Tel: 01903 737756
Email: planning@arun.gov.uk
www.arun.gov.uk/planning
Please ask for: Ms Ella Summerfield
Email: ella.summerfield@terraquest.co.uk
Telephone: 0121 2341390
Our Ref: BE/51/26/HH
Your Ref:
Date: 14th July 2026

Application for Planning Permission for Works or Extension to a Dwelling

Development: Installation of a modular access ramp to provide level wheelchair access to the dwelling, together with the creation of a new ground floor WC.
Location: 9 Birdham Close Bersted PO21 5TD

9 Birdham Close, Bognor Regis, PO21 5TD

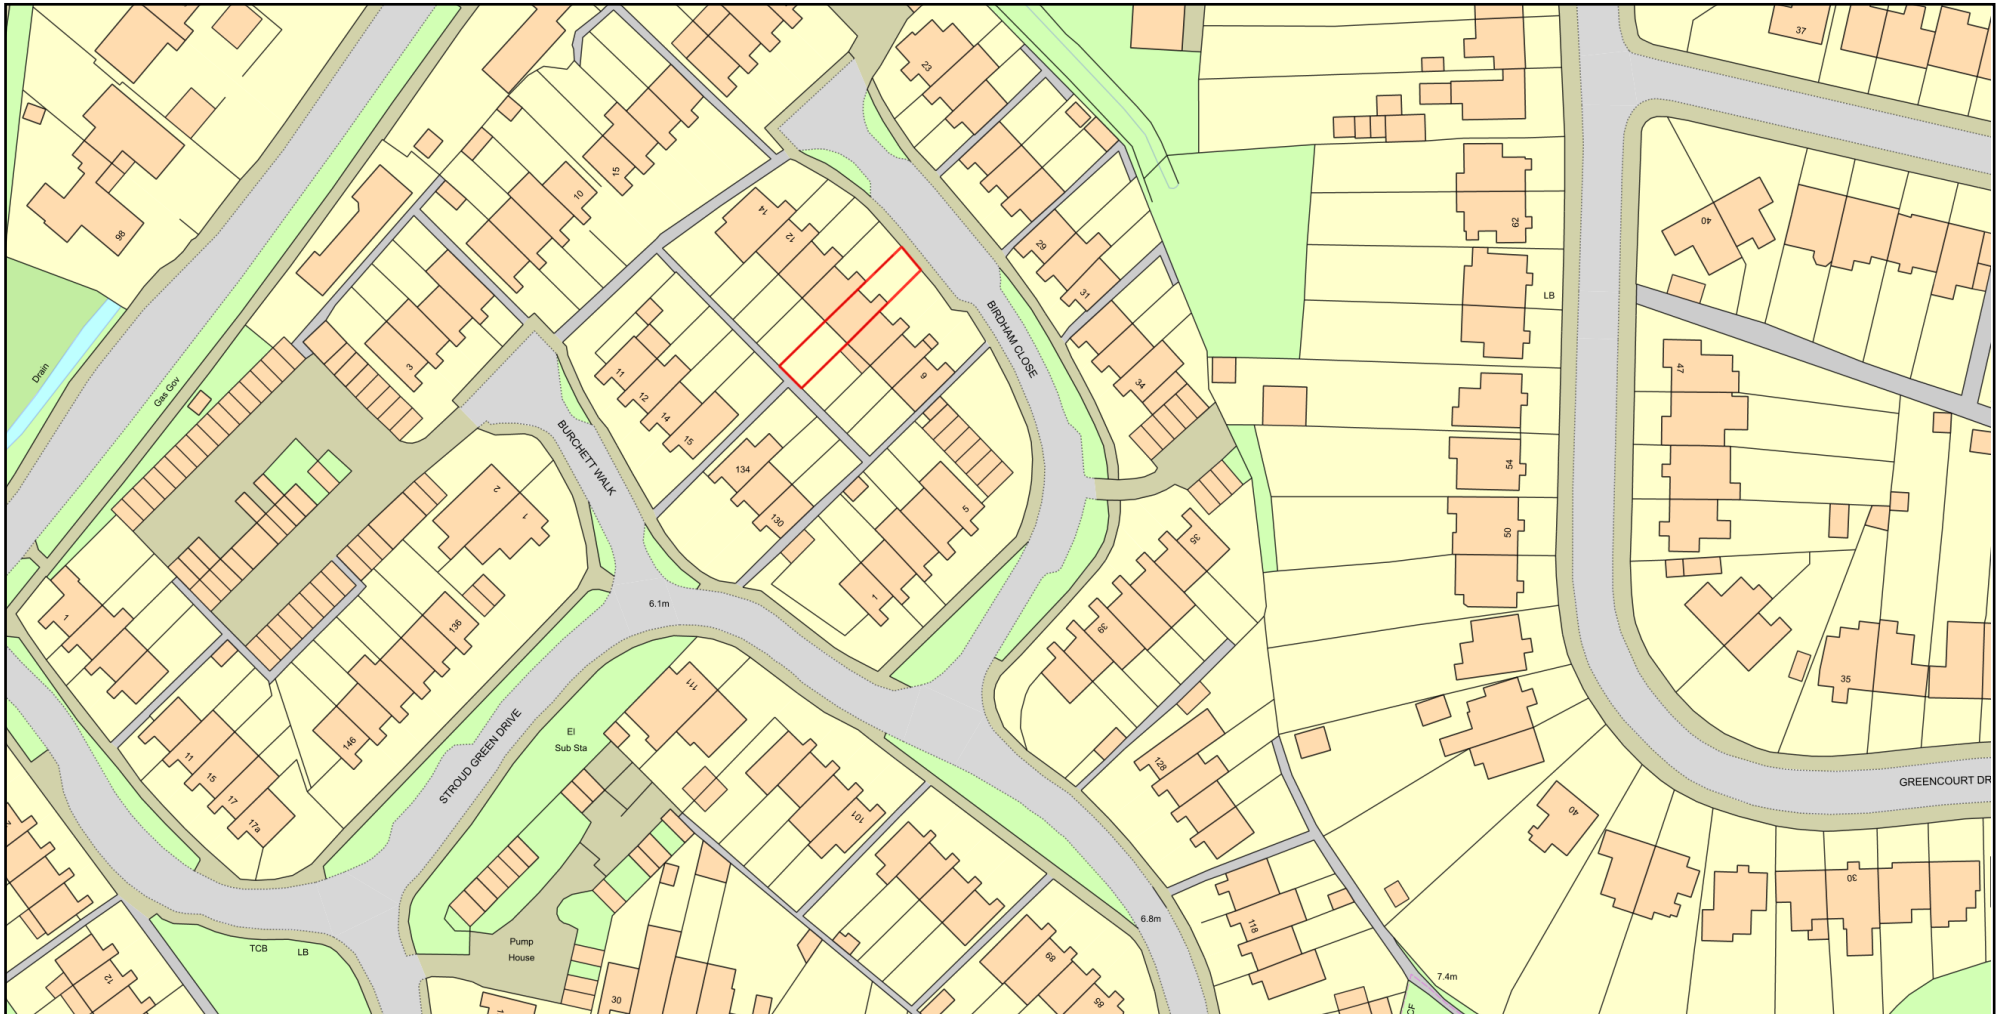
The block plan requires dimensions from the extension to the site boundary. Please amend.

Both block and location plans have No.10 outlined instead of No. 9. Please amend.

Downstairs WC and access

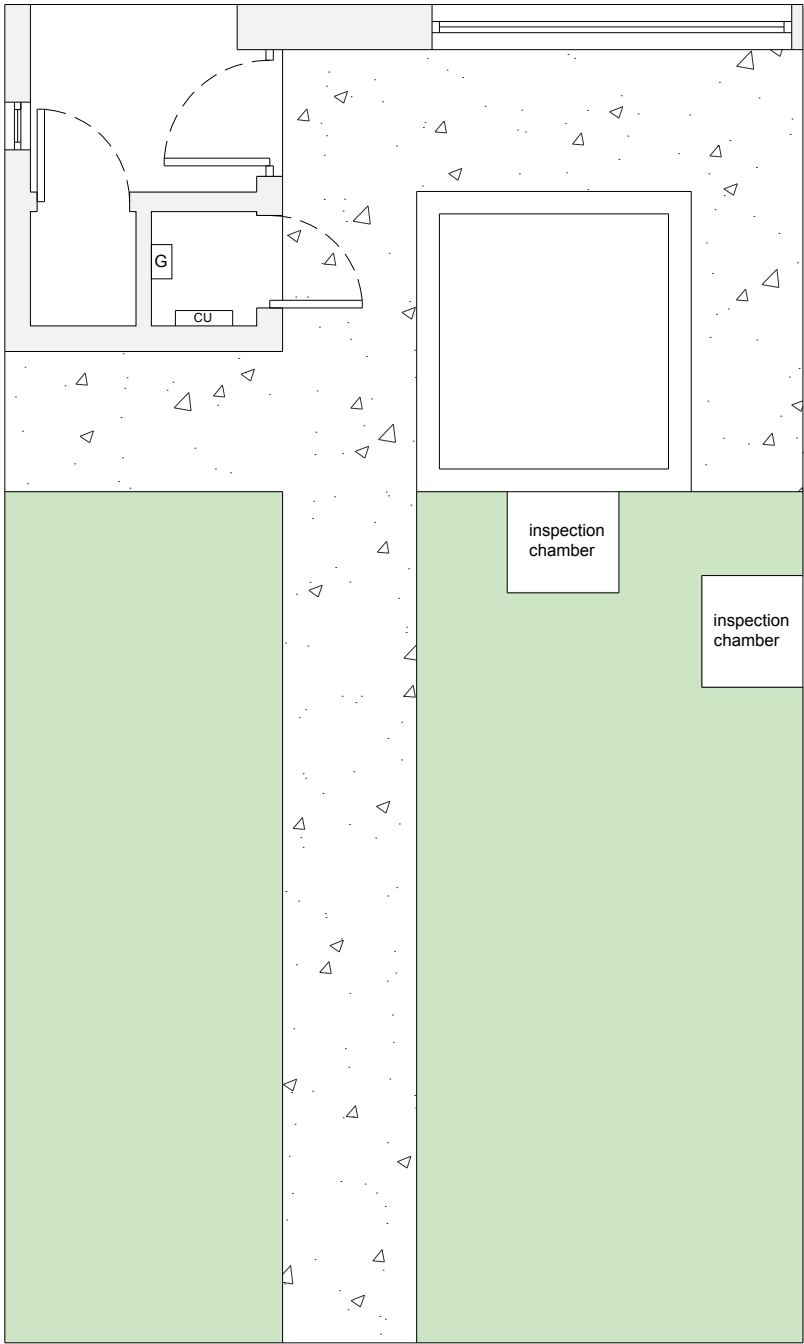
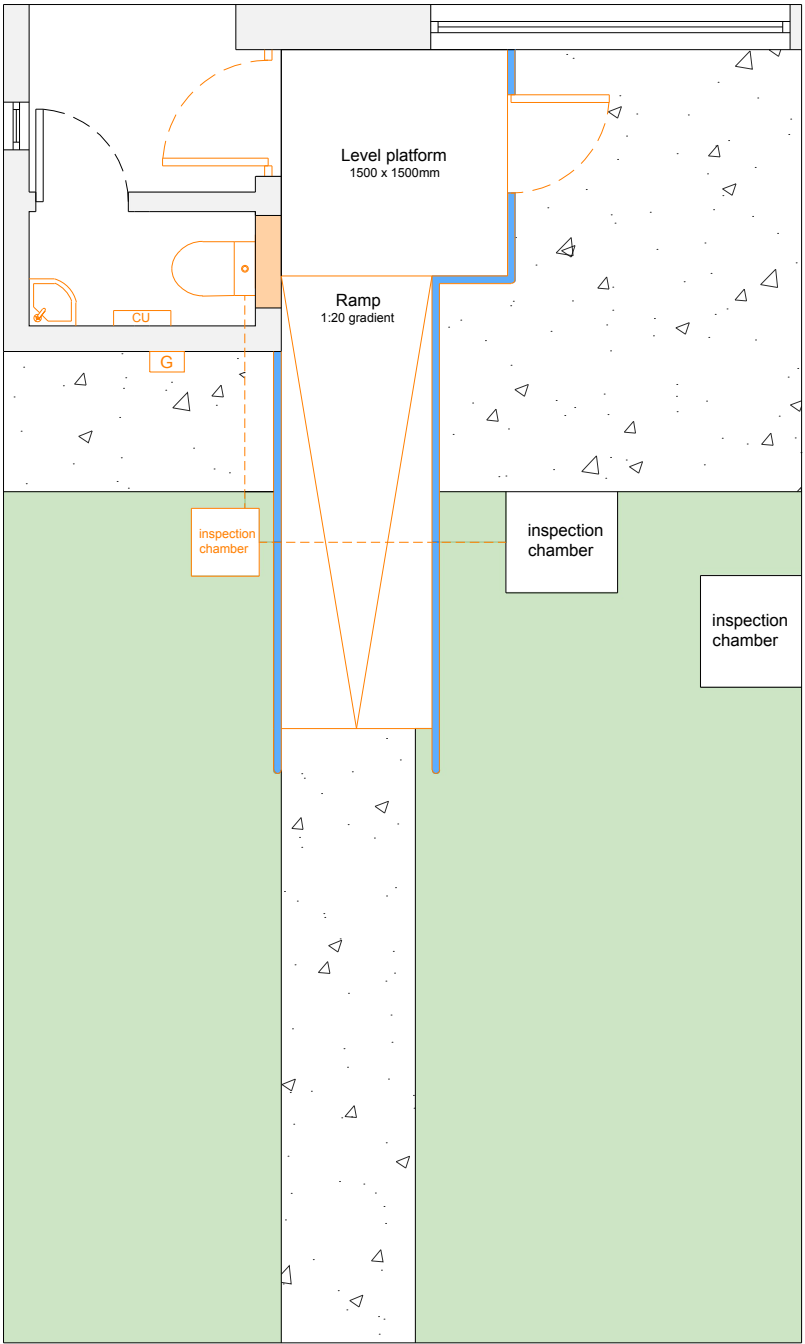
Windows and doors on elevation plans need to be more clear, they blend too easily into the other features of the house. Please amend.
